Please ask for: Mrs D Johnson
Email: daun.johnson@arun.gov.uk
Telephone: 01903 737762
Our Ref: AL/130/24/CLP
Your Ref:
Date: 21st November 2024

Lawful Development Certificate for a Proposed Use or Development

Development: Lawful development certificate for the proposed demolition of existing garage and erection of a single storey garden building/outhouse.
Location: Little Lamorna Lidsey Road Woodgate PO20 3SU

Mr. A Hammett  
Little Lamorna, Lidsey Road, Bognor Regis,  
West Sussex, PO20 3SU  
PROPOSED ELEVATIONS  
A3 PAPER  
Date Nov 2024 Scale 1:50

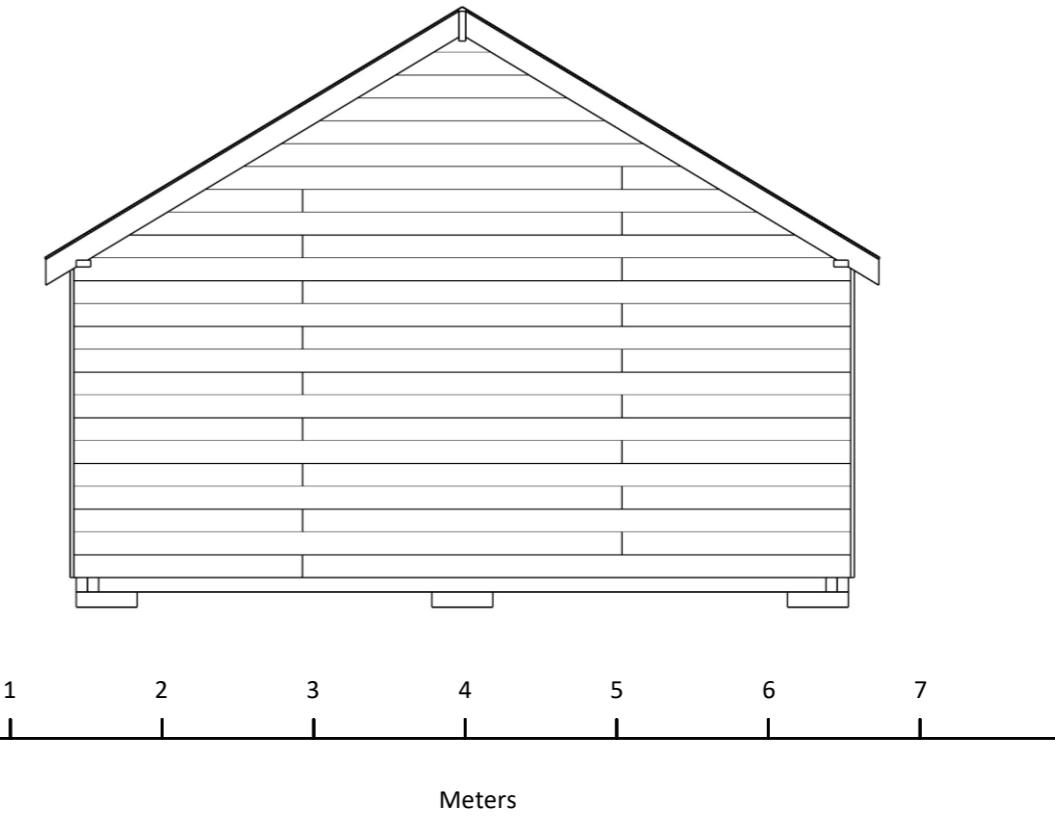
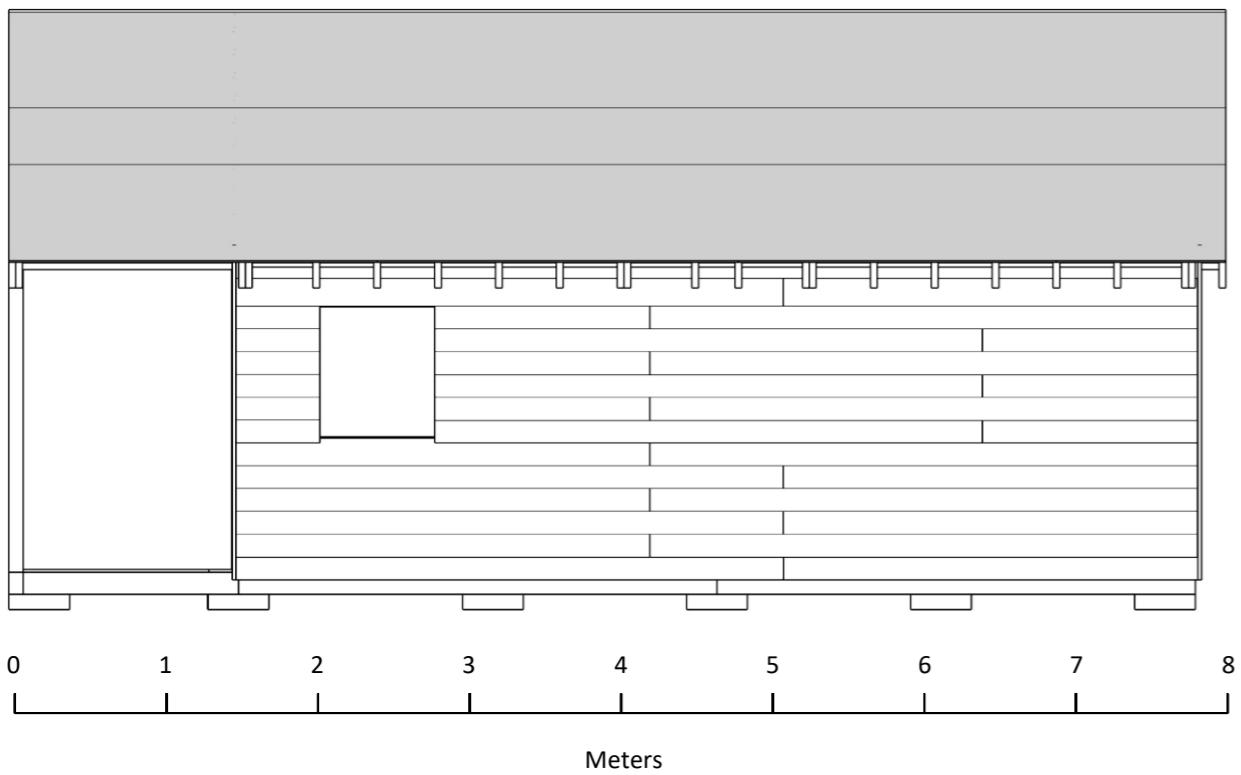
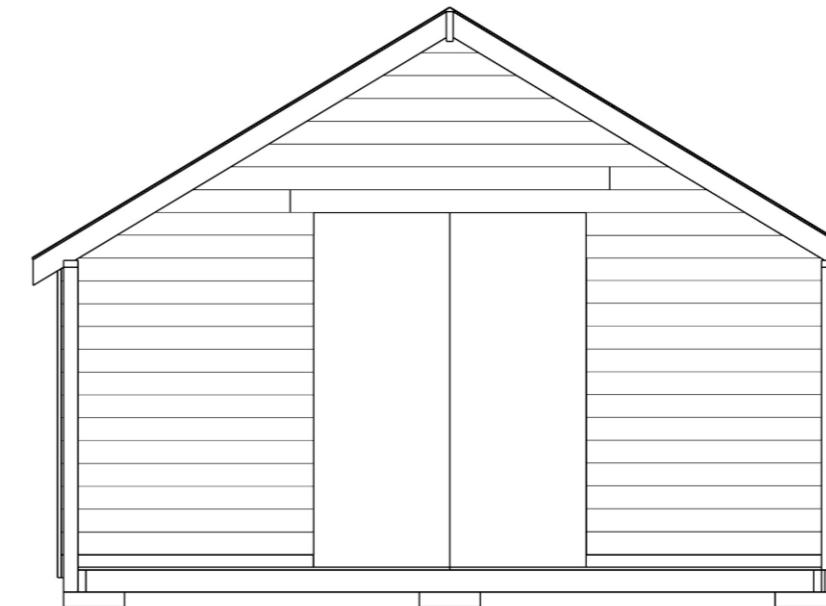
The proposed north and south elevations do not accord with the floor plan. Please amend accordingly.
